Our Ref: R/50/20/HH

Town & Country Planning Act 1990 (as amended)
Town & Country Planning (Development Management Procedure) (England) Order 2015
Application for Planning Permission for Works or Extension to a Dwelling

Development Side extension over garage, single storey rear extension and front porch.

Location 47 Priory Road Rustington

DRWG TITLE: **Proposed site plan**

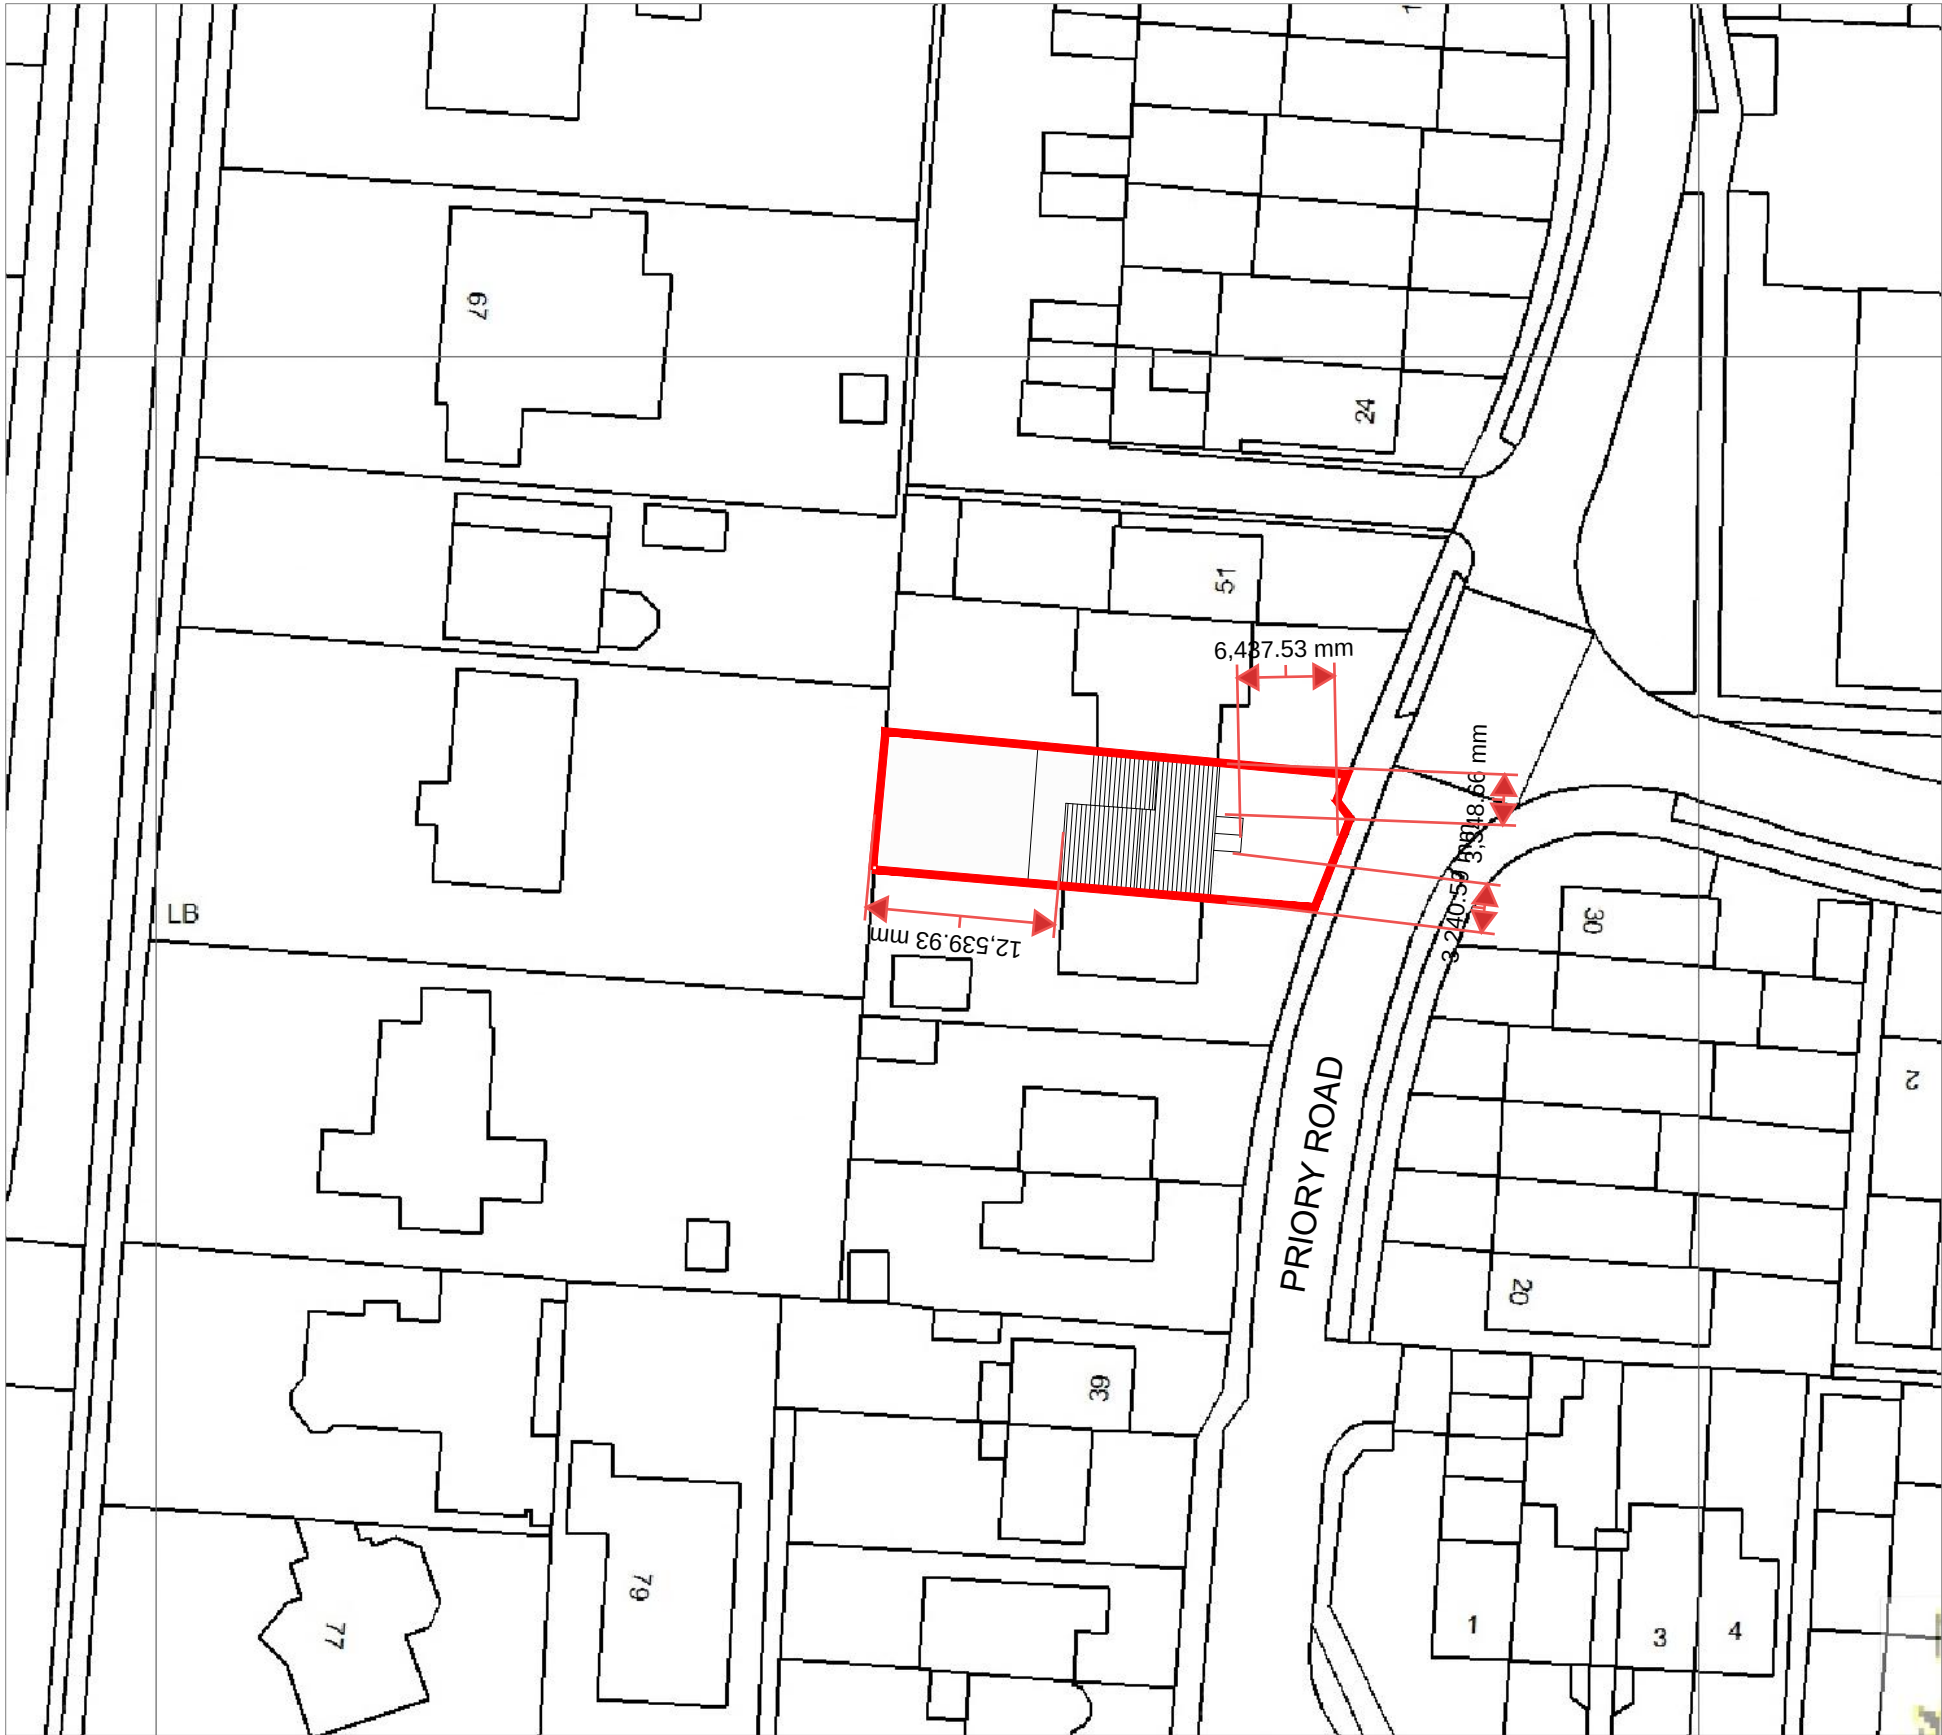
Block Plan: You are required to include dimensions on the block plan from the proposed extension to all site boundaries.
